From: Mark Taylor [REDACTED]
Sent: 14 October 2014 16:25
To: Peter Cleveland
Subject: RE: A/137/14/DOC - Archaeological WSI

From: Peter Cleveland [<mailto:Peter.Cleveland@arun.gov.uk>]
Sent: 14 October 2014 15:50
To: Mark Taylor
Cc: Andrew Wood
Subject: FW: A/137/14/DOC - Archaeological WSI

Further to your comments regarding the above site, please find attached the Archaeological remediation report for the Barratts scheme to the east of Roundstone Lane, Angmering.

Proposed trench location

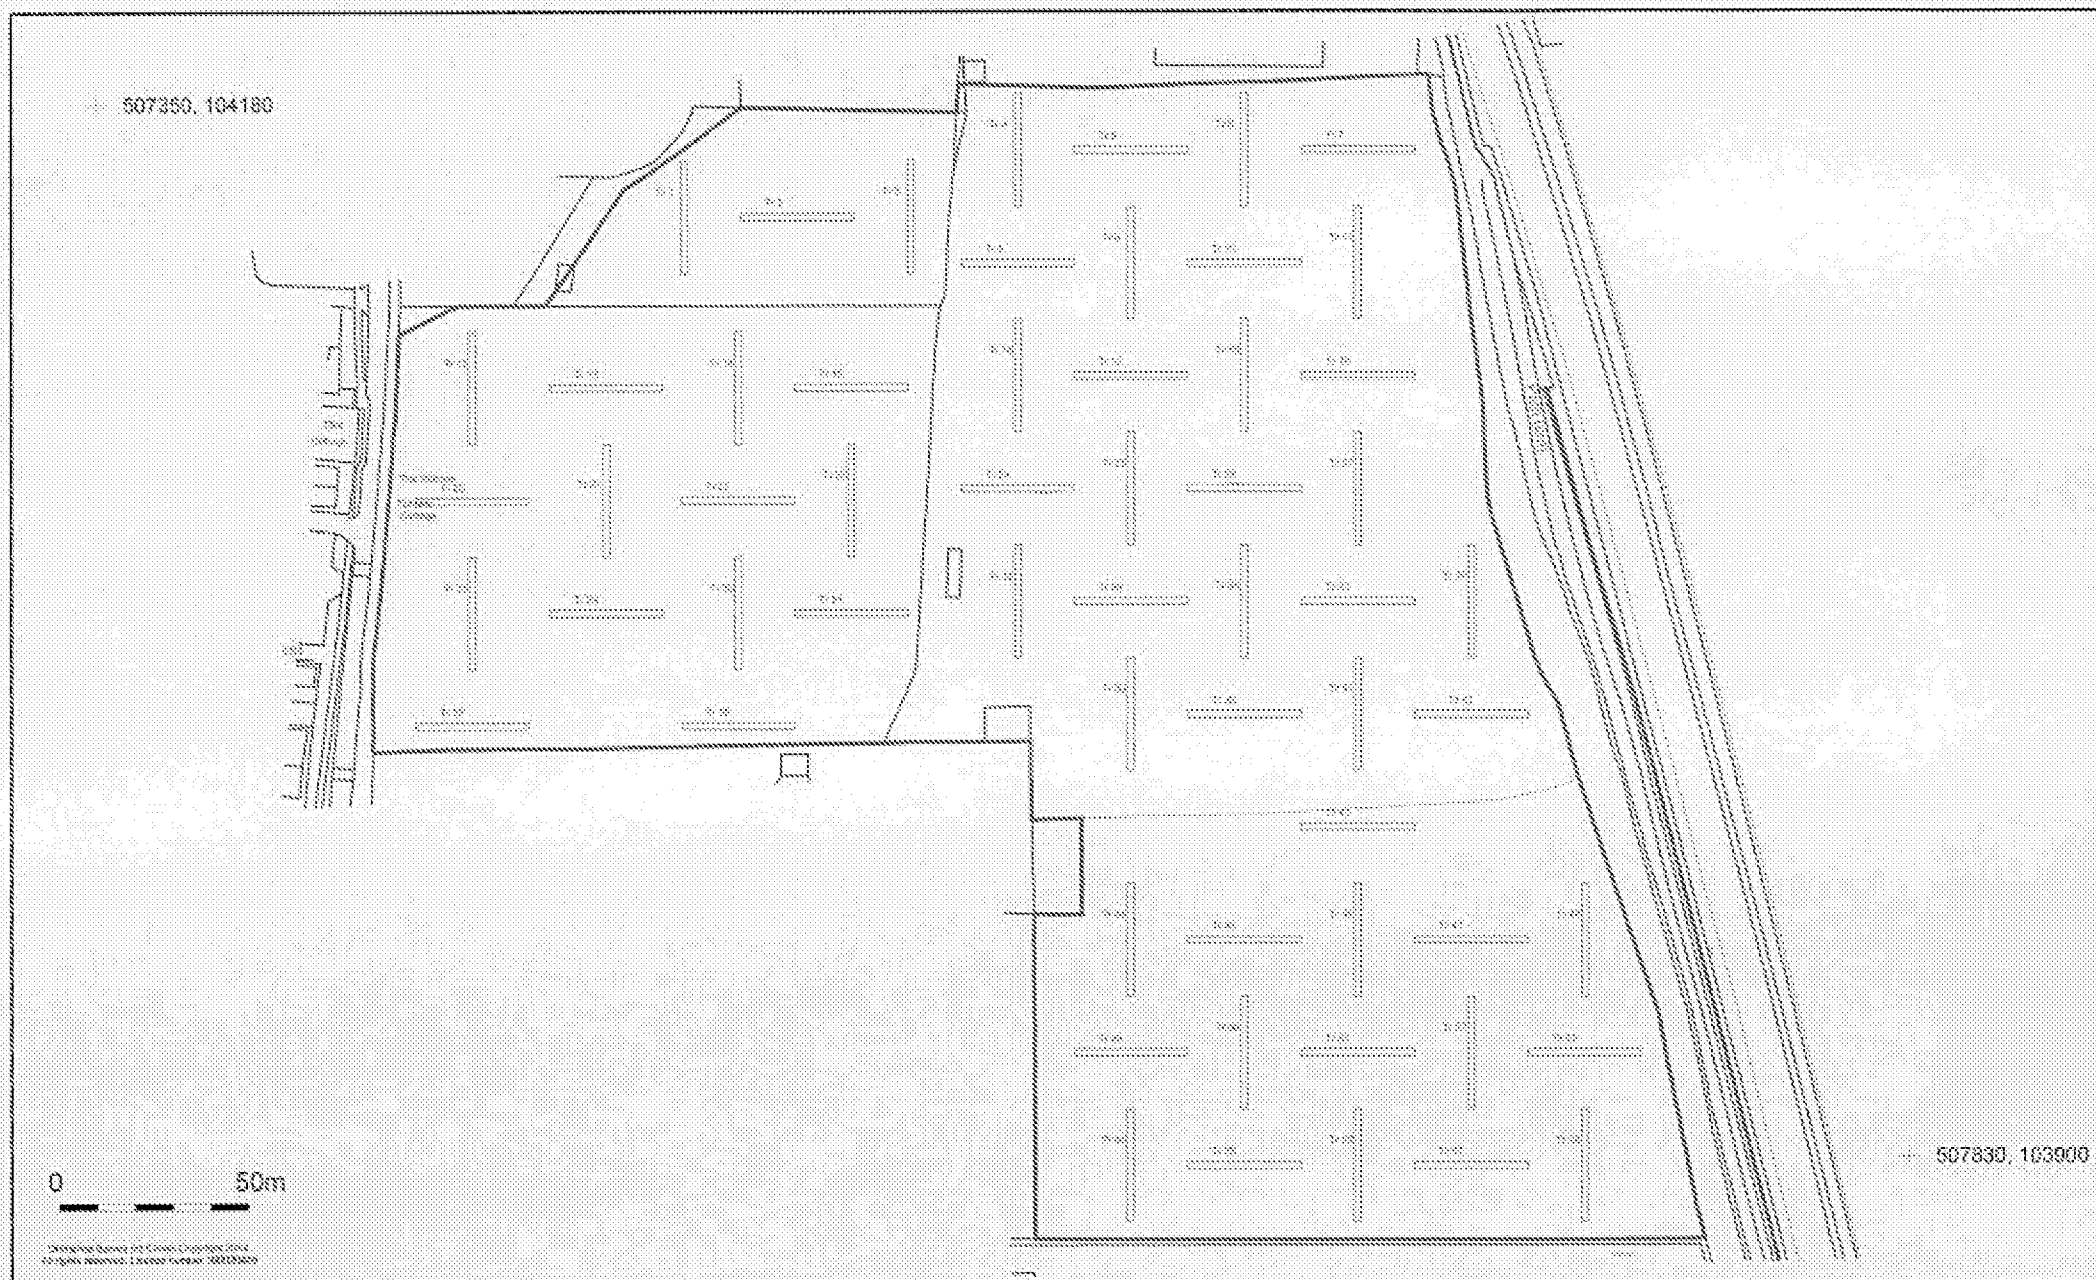
Dear Peter, many thanks for this. I have read the WSI and I am happy to recommend it to Arun for approval. There is also a contingency under section 4.2 to extend the area of stripping, once it is under way, if archaeological features look as though they will continue beyond the notional edge of investigation set out in the figure at the end of the document. Regards and best wishes, Mark
